Our reference: ECM 9378541  
Contact: Robert Craig  
Telephone: (02) 4732 7593

**Request for Comments – SSD-10448 – Aspect Industrial Estate, Lots 54-58 DP 259135, 788-882 Mamre Road, Kemps Creek**

Mamre Road Frontage

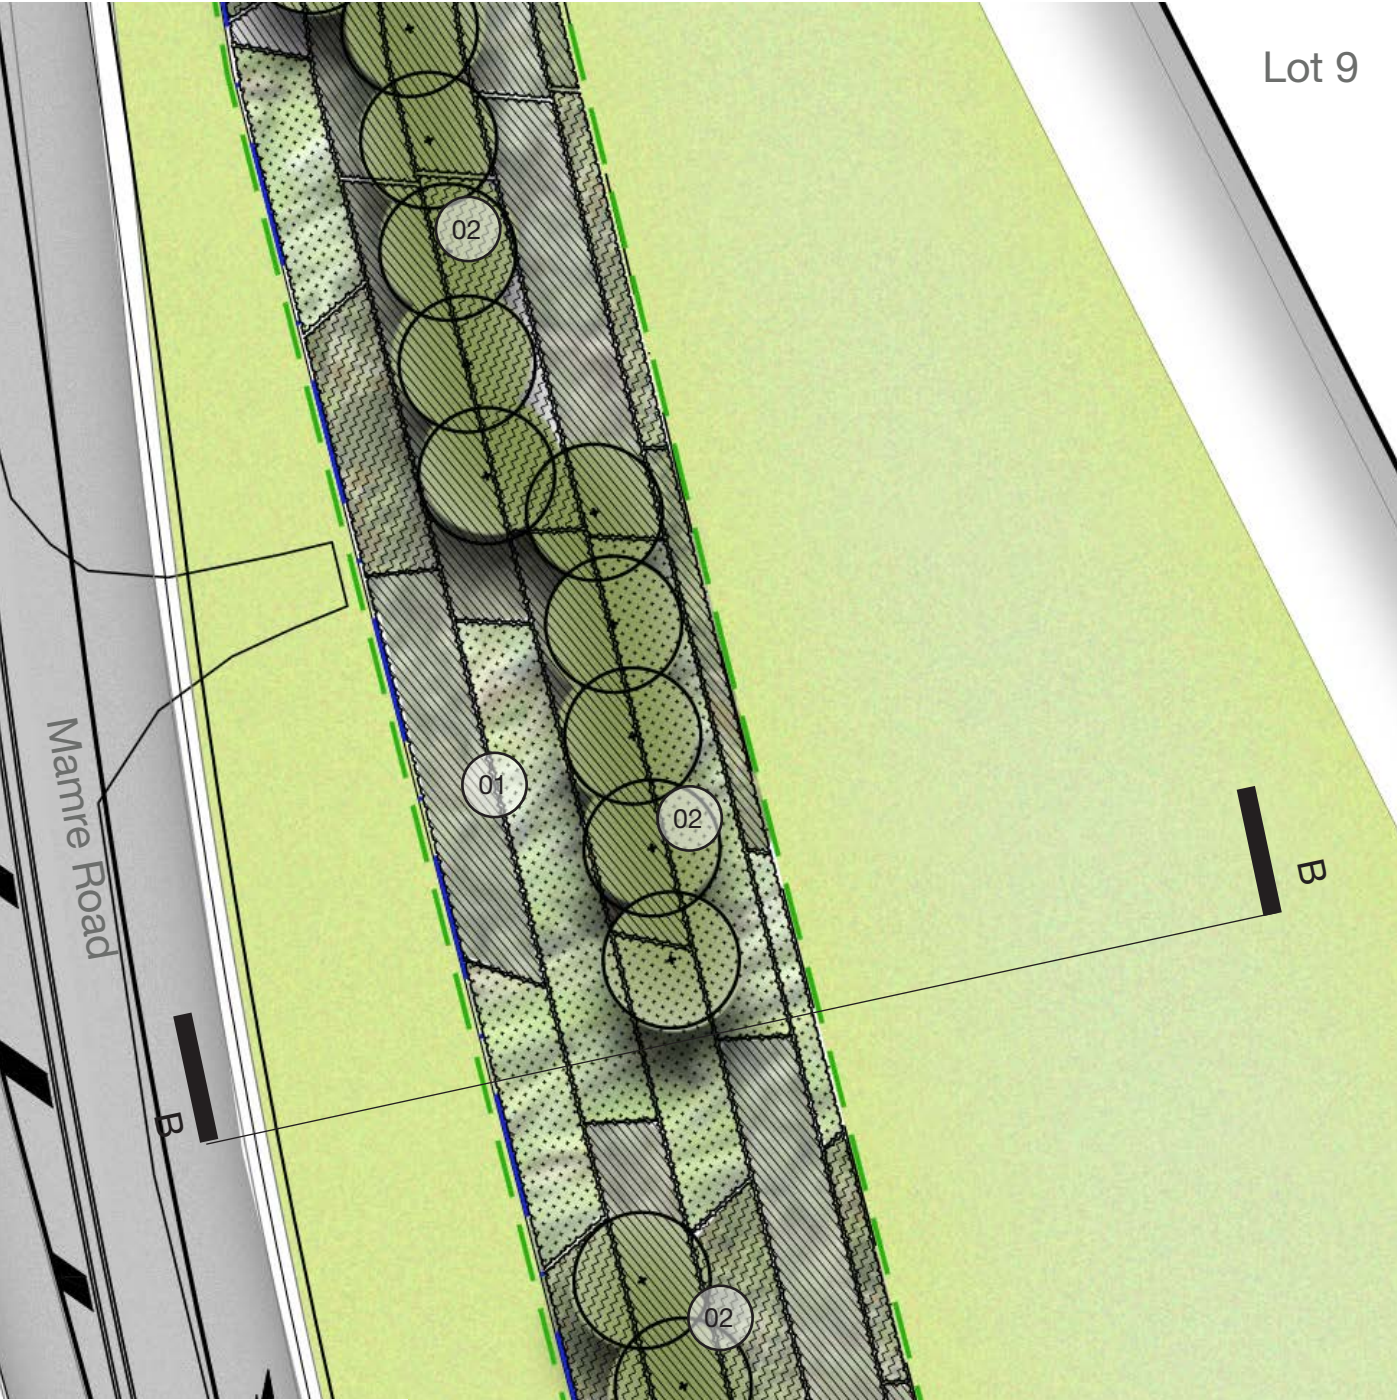
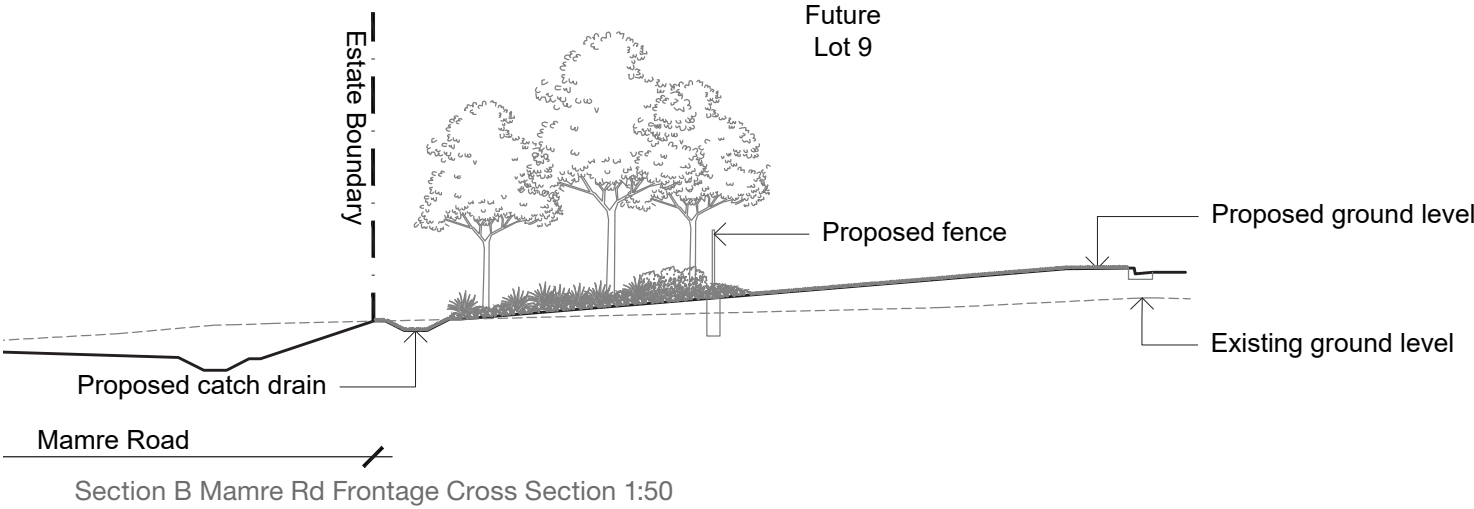
In relation to the proposed landform and treatment of setback areas relative to the Draft Mamre Road Precinct DCP provisions, concerns are raised regarding the suitability of the Mamre Road setback treatment (in particular the inclusion of batter areas and the siting of a large stormwater basin) and the excessive height of proposed retaining walls (for example at the estate edges).

The batter of the estate basin along the Mamre Road frontage shall be located clear of the proposed future widened road reserve boundary for Mamre Road. Grass batters shall be at a maximum of 1 in 5 (vertical to horizontal).

Section C Road 01 Section 1:50

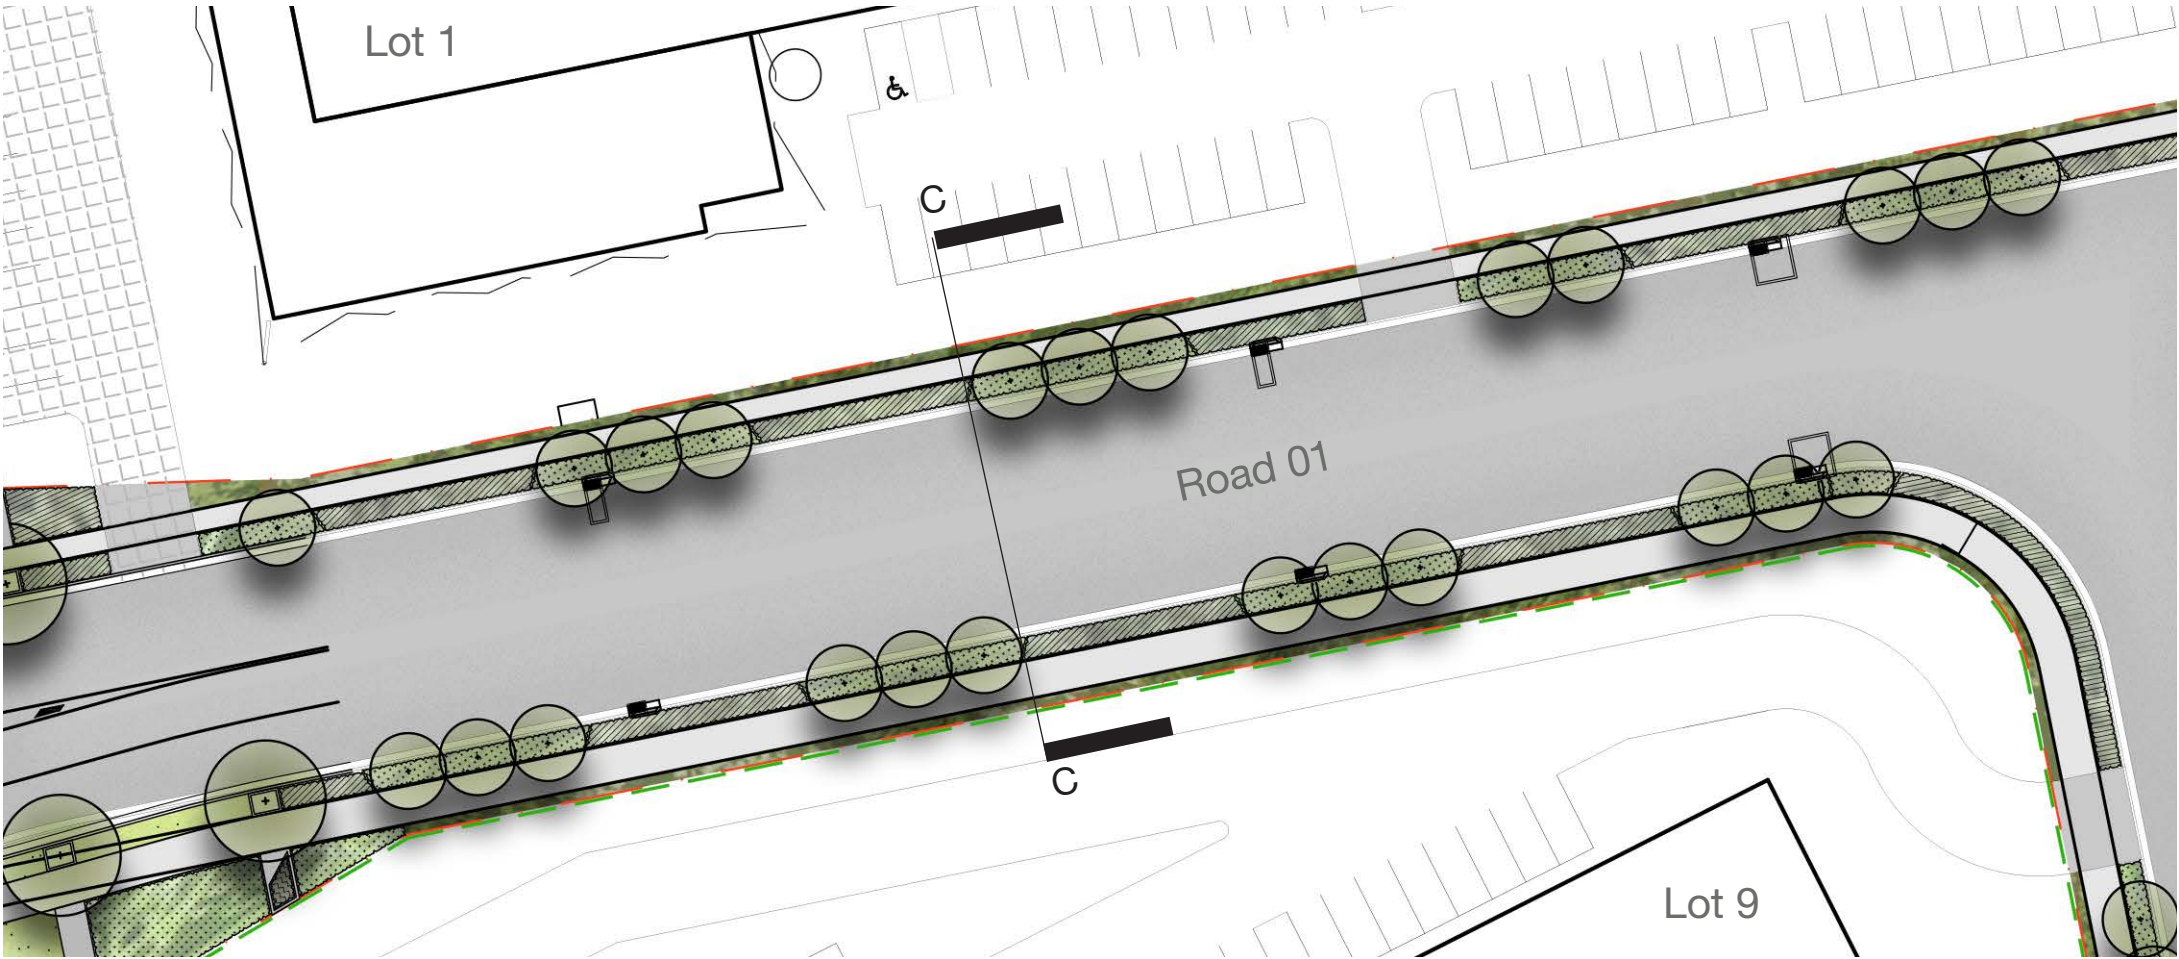
Estate Road 01 aligns with the high order road as per the draft DCP and shall be designed as a *Distributor / Collector Road* with a 26.4m wide road reserve with associated pavement widths and verge widths to be in accordance with the draft DCP.

Section D Road 2 Section 1:50

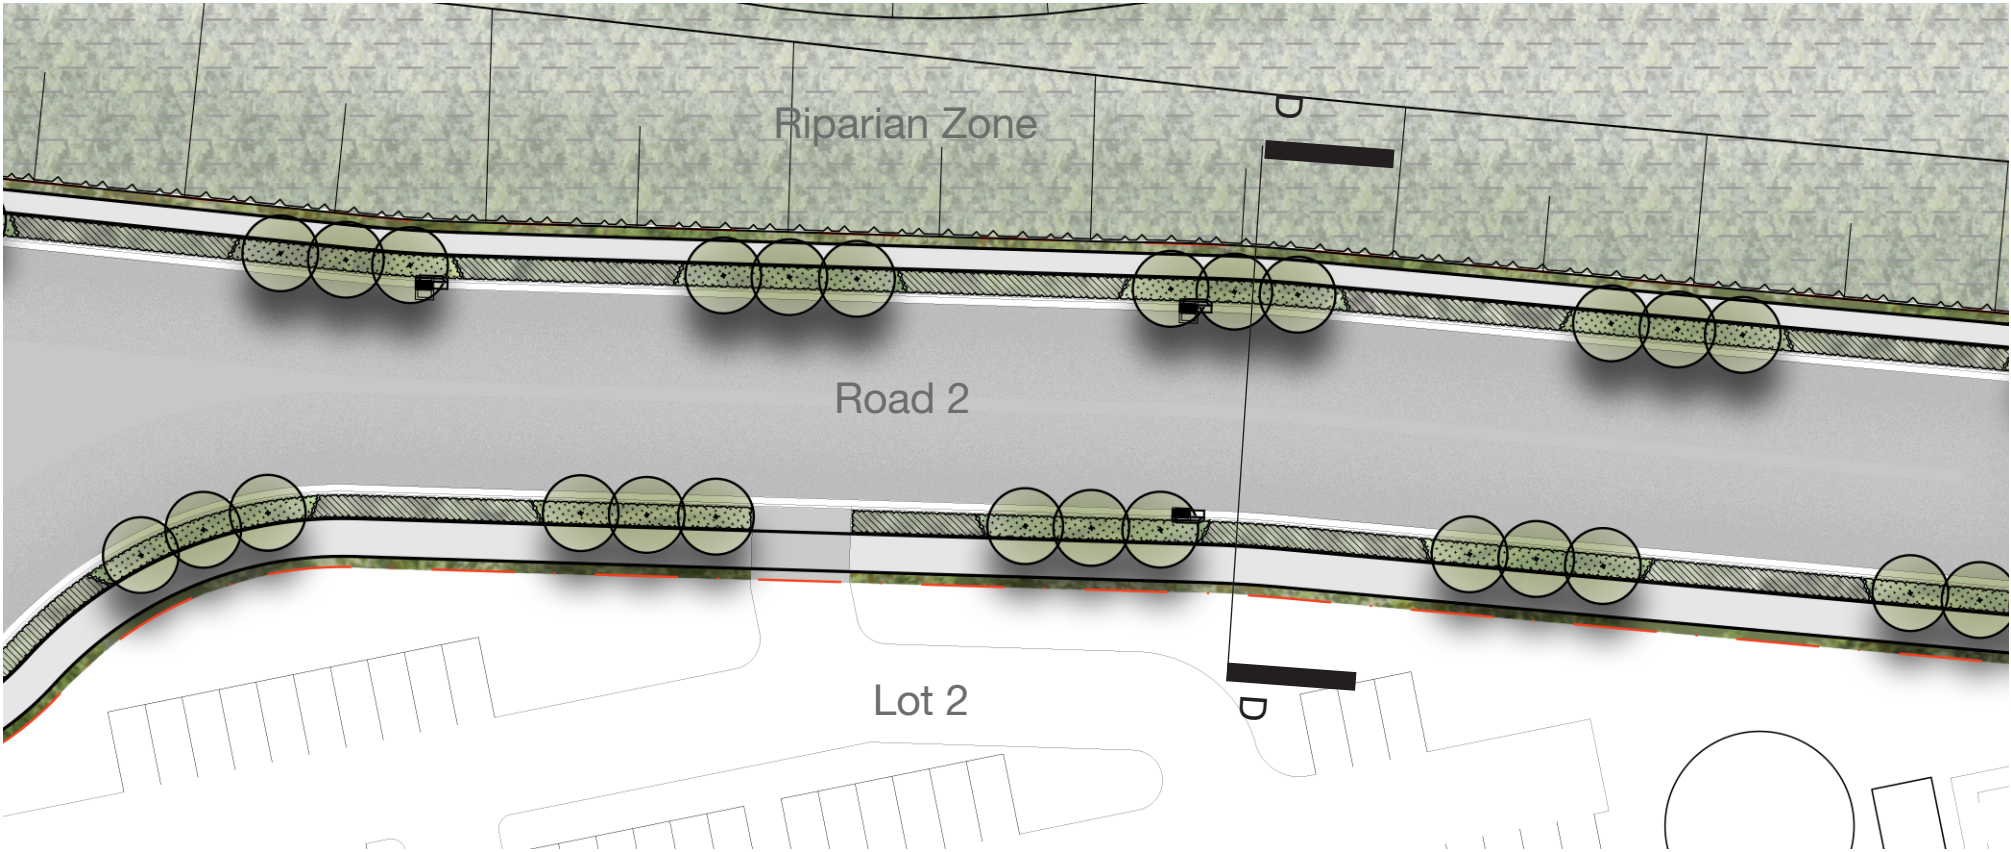
Estate Road 02 shall be designed as a *Local Industrial Road* with a 24m wide road reserve with associated pavement widths and verge widths to be in accordance with the draft DCP.
